Sent: 06 June 2009 21:05
To: Planning
Subject: Appeal Against Planning Application: S6/2009/0891/MA

I am contacting you to appeal against planning application **S6/2009/0891/MA**, specifically **building B29** of the proposed **East Square**.

DRAWING TITLE
B29 - ELEVATIONS

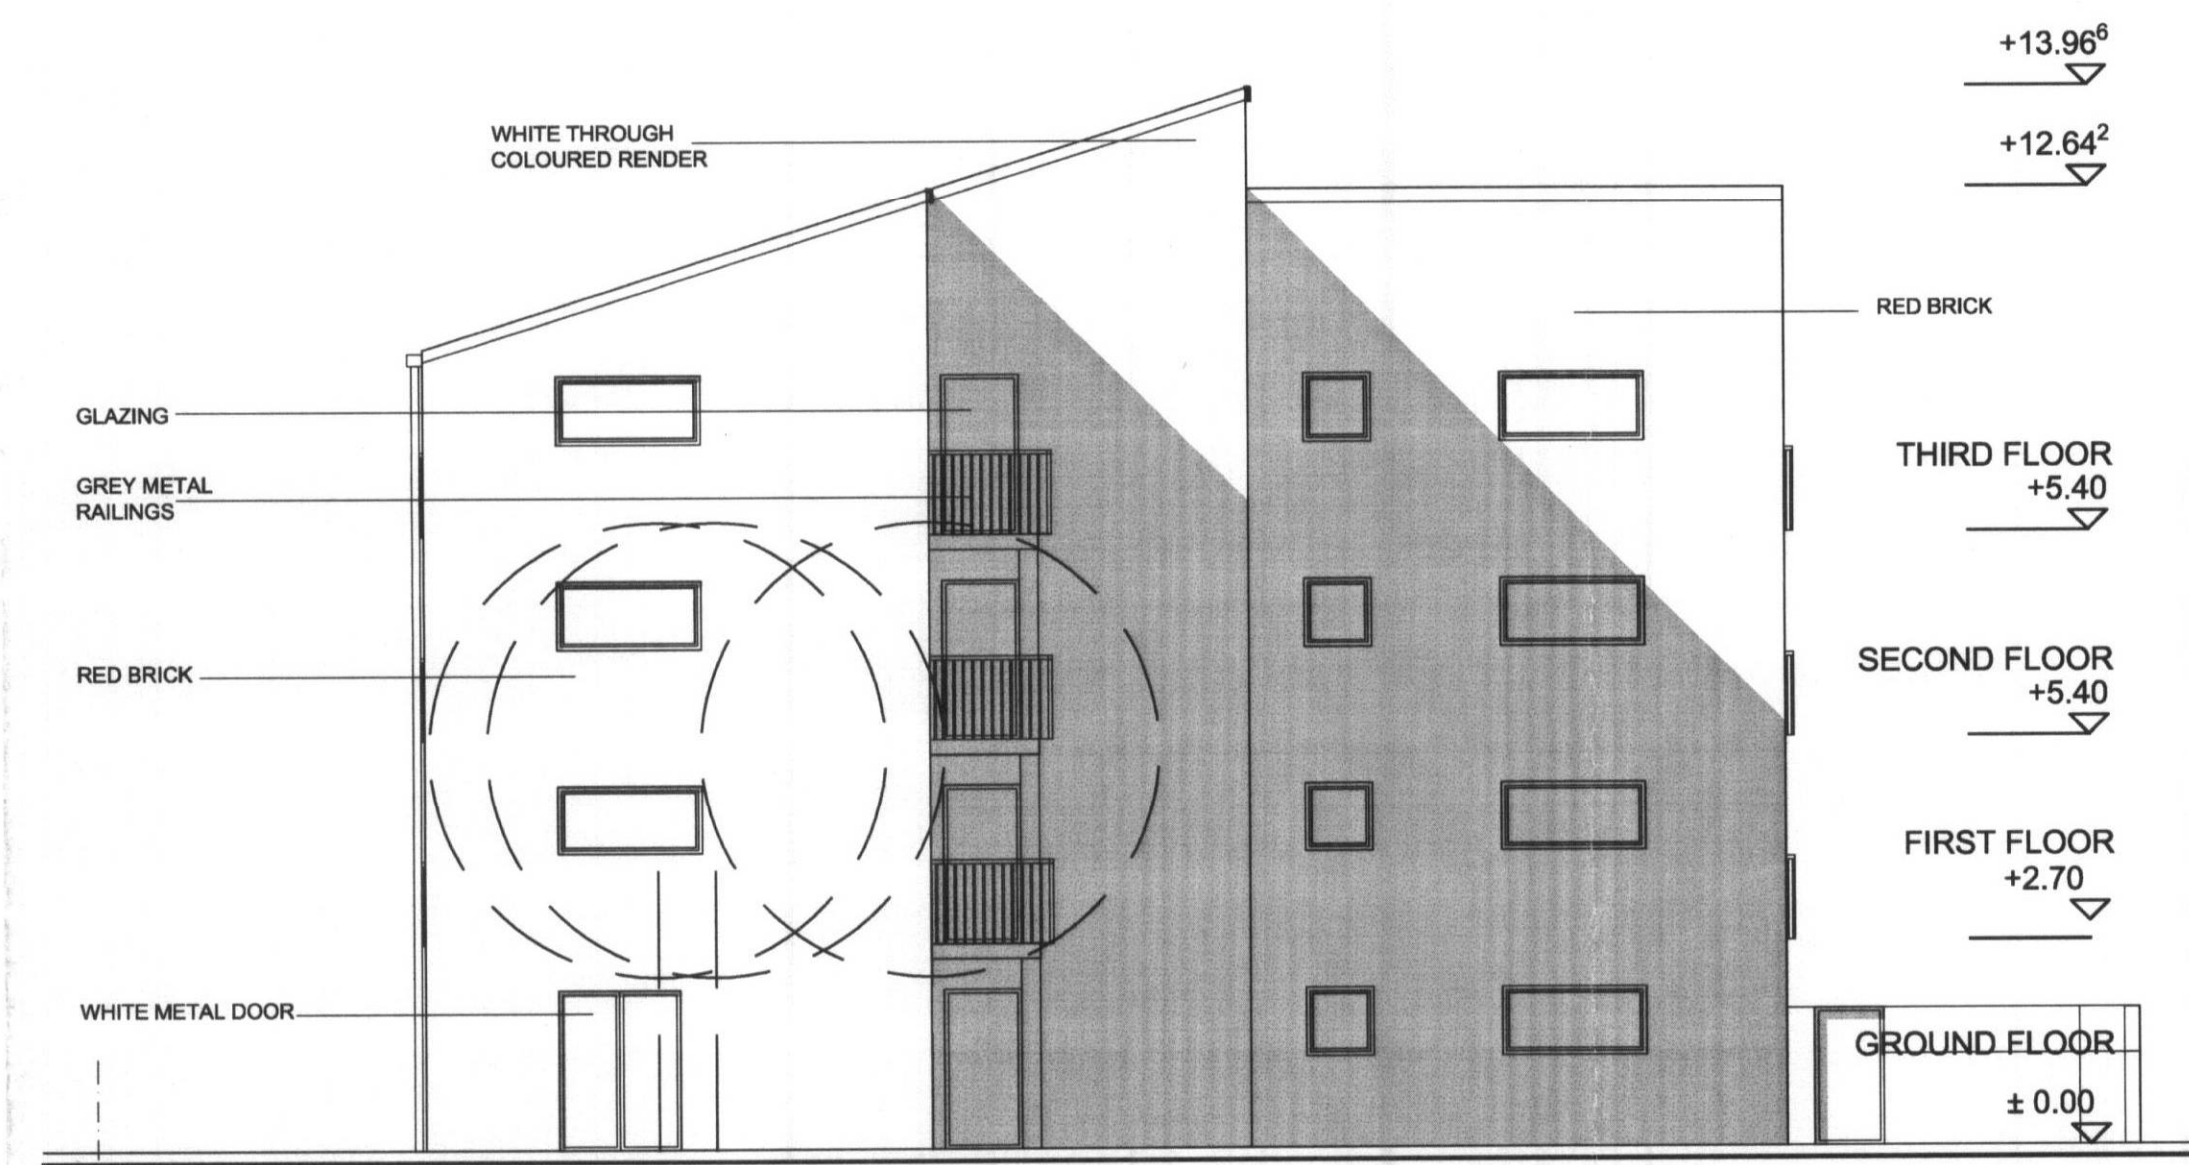
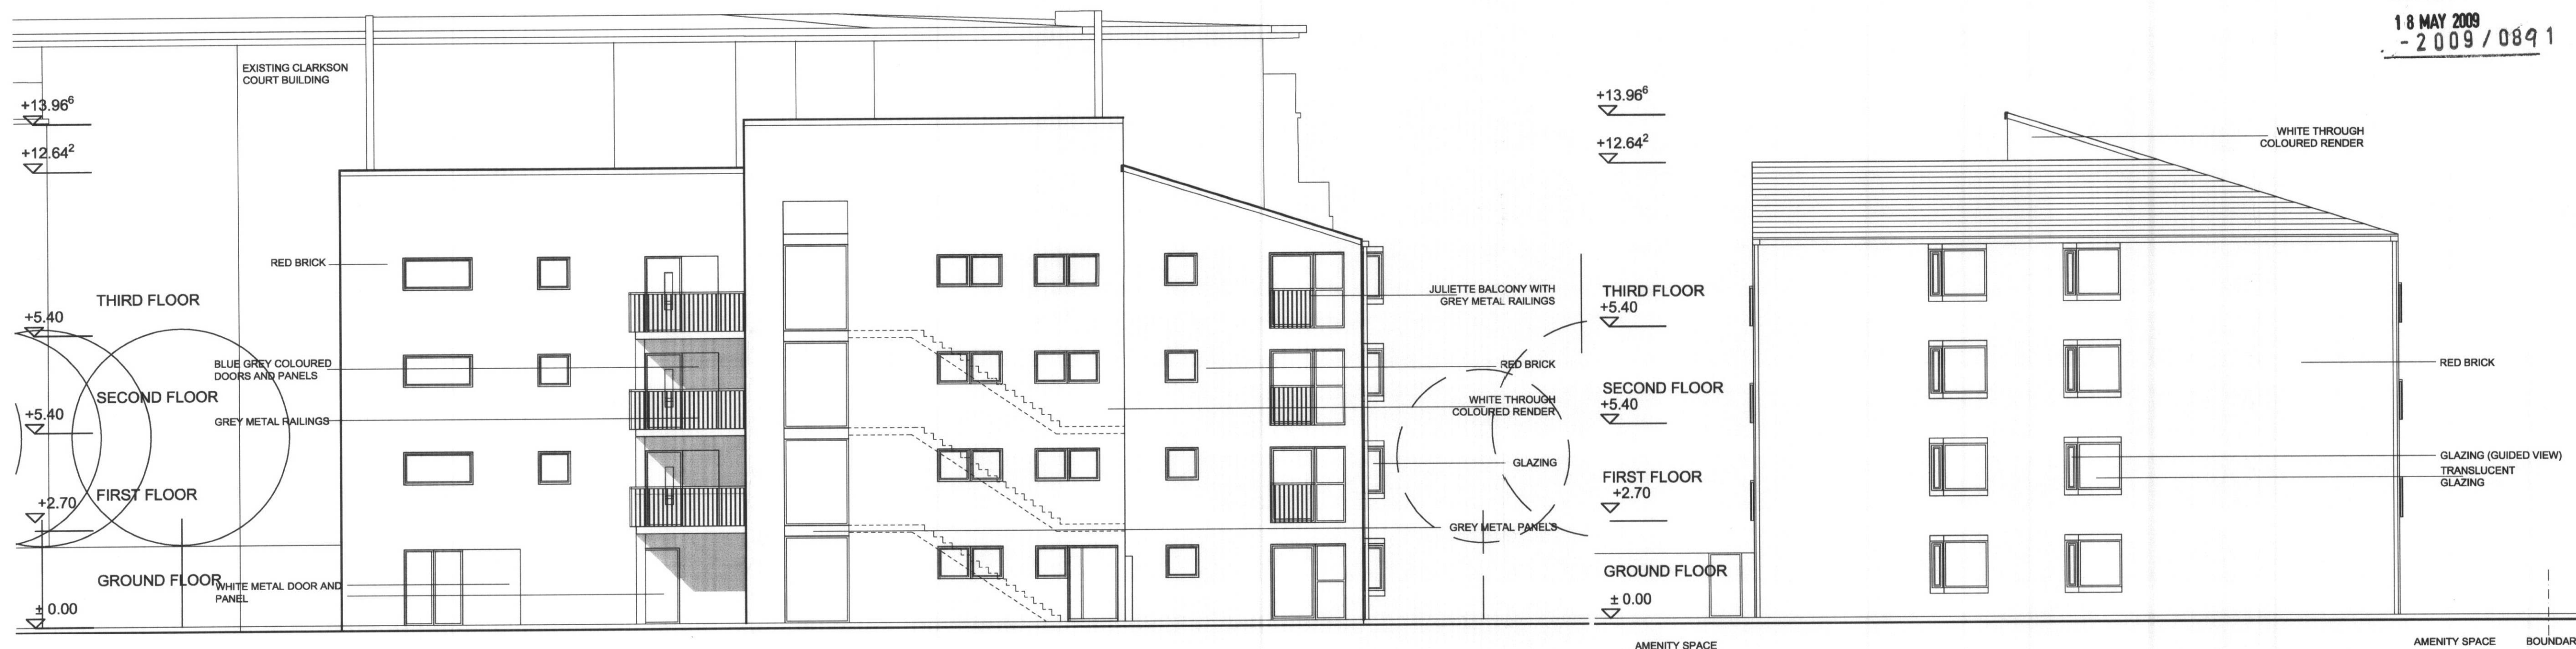
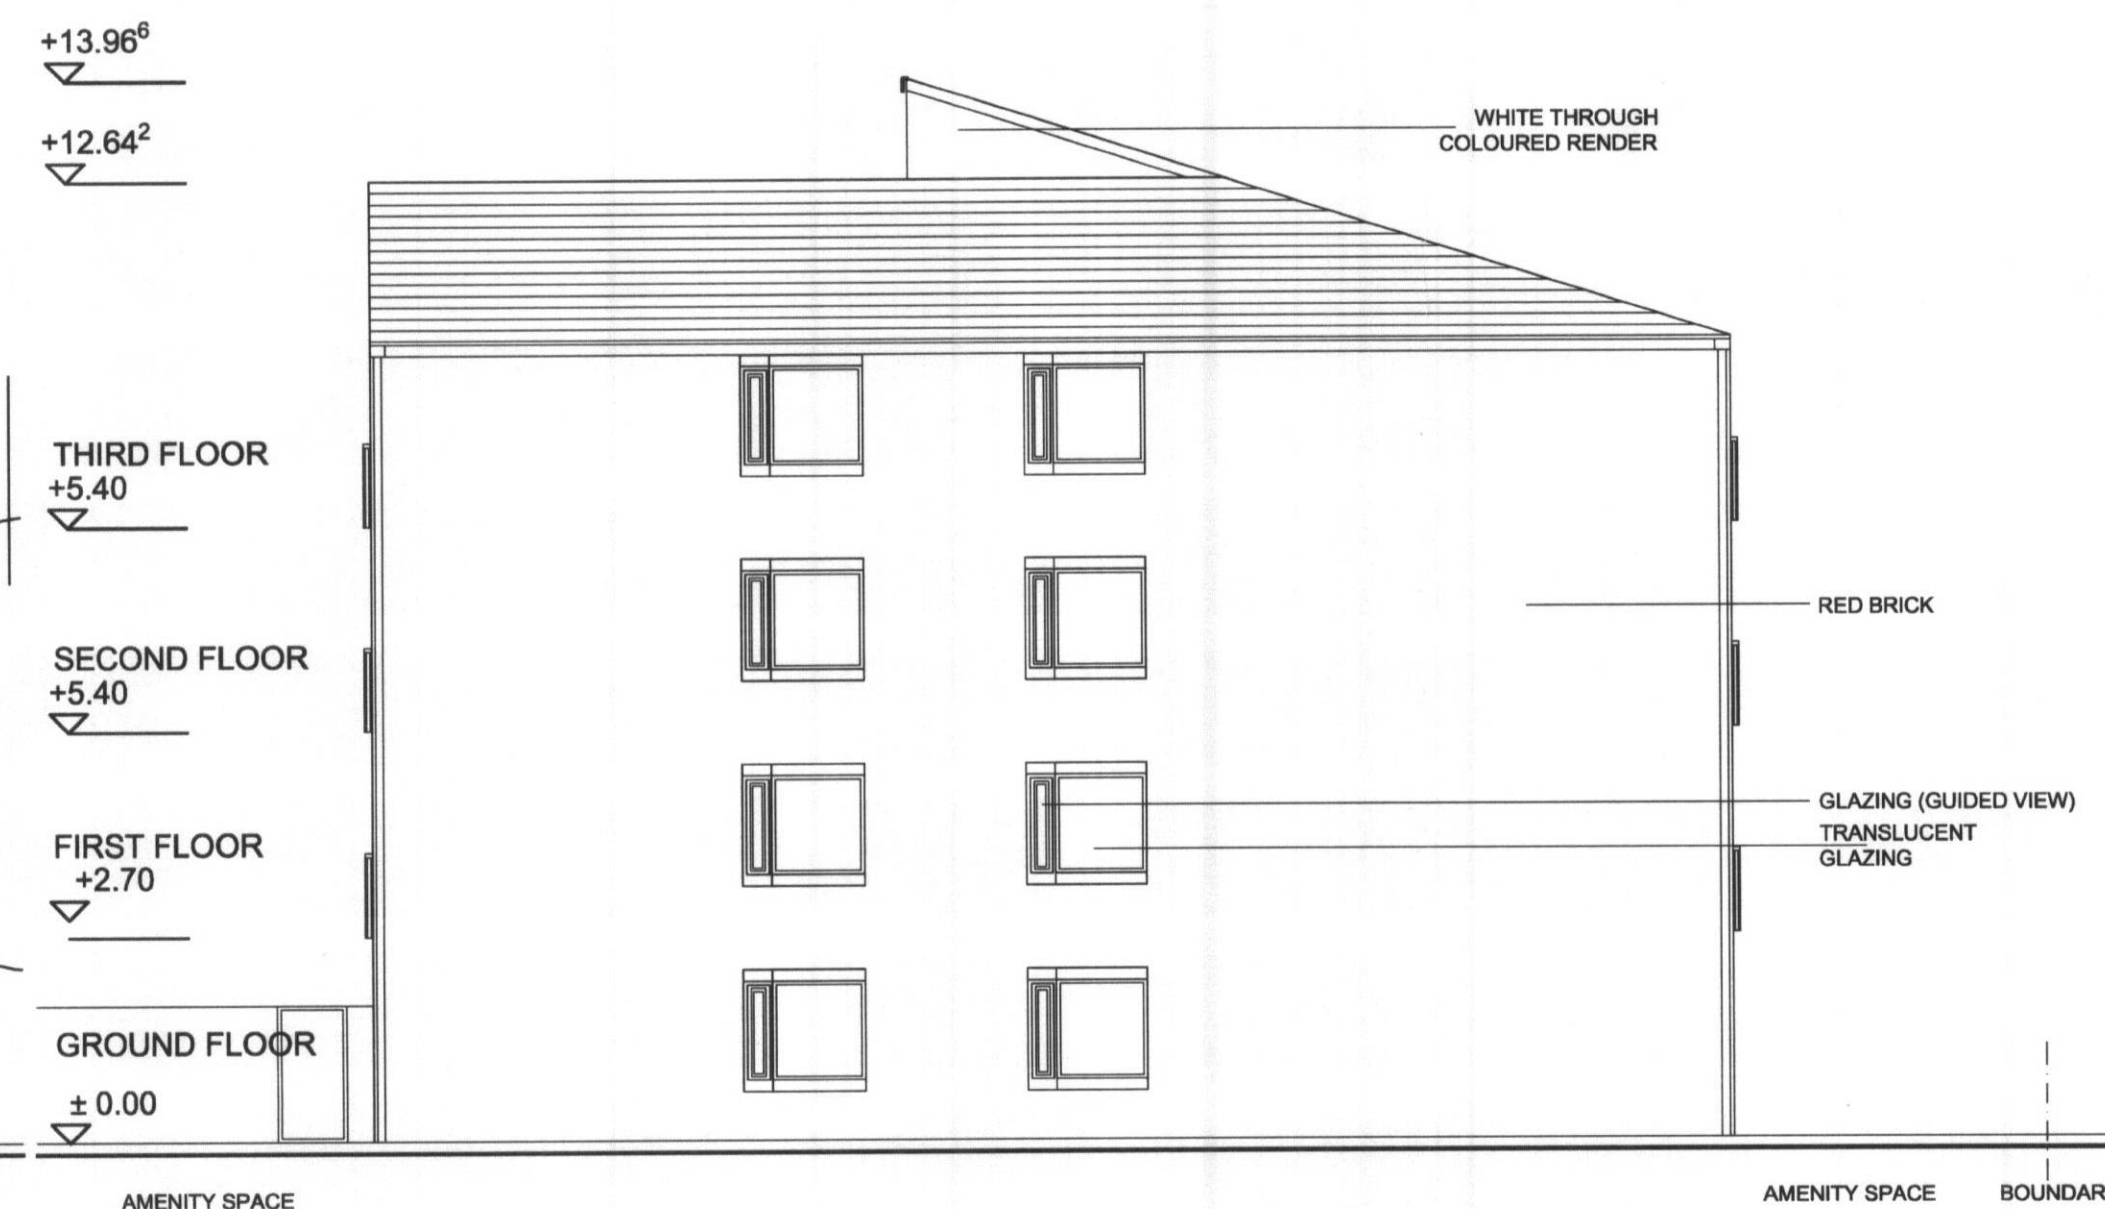
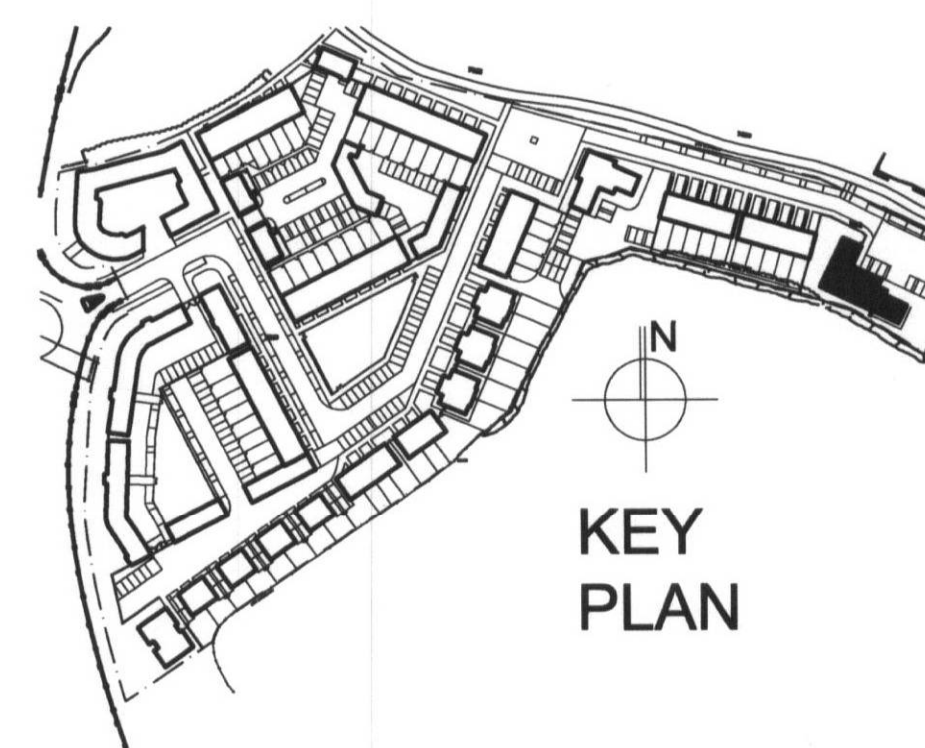
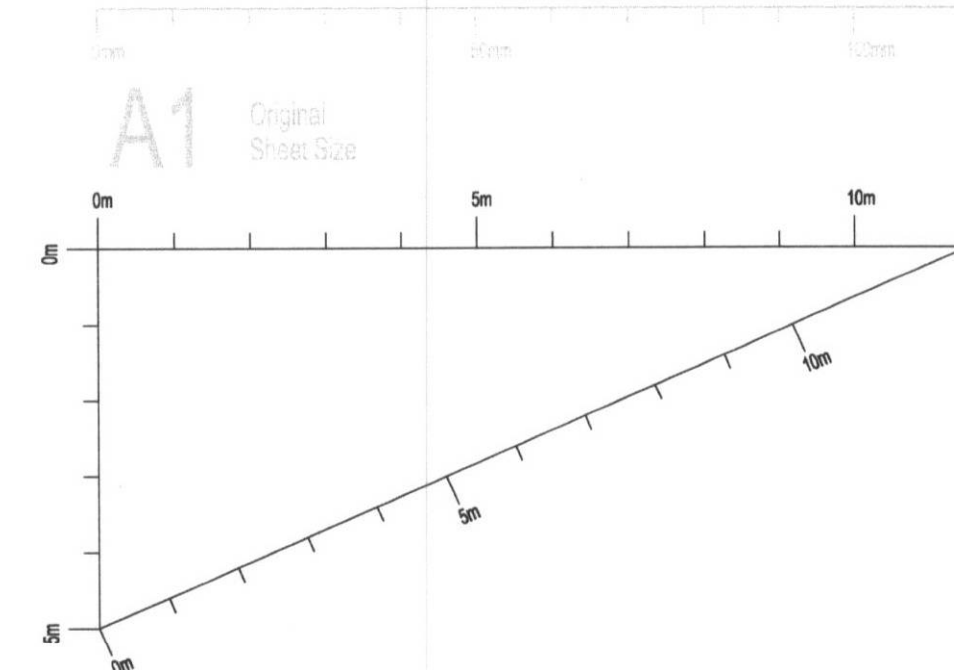
I am a resident of **Clarkson Court** and my apartment and balcony will directly overlook the proposed four storey building (B29). I am greatly concerned that this will ruin the view from my apartment and affect the value of my property. Not only will the building itself block my view, but I will overlook a car park for what appears to be 10-15 cars. This will not only be an eyesore, but will generate noise which is a concern when my bedroom faces directly onto it.

When I purchased my apartment at Clarkson Court in 2005, I was verbally assured by the developer (Barratt) that the patch of land now intended for B29 was going to be communal gardens. I realise this has no legal grounding, but it has made the proposed plans even more distressing. In an area which is fast becoming so built up, this would be a more appropriate use of the space in my opinion.

I would therefore like to state my appeal against building B29 of the proposed application.
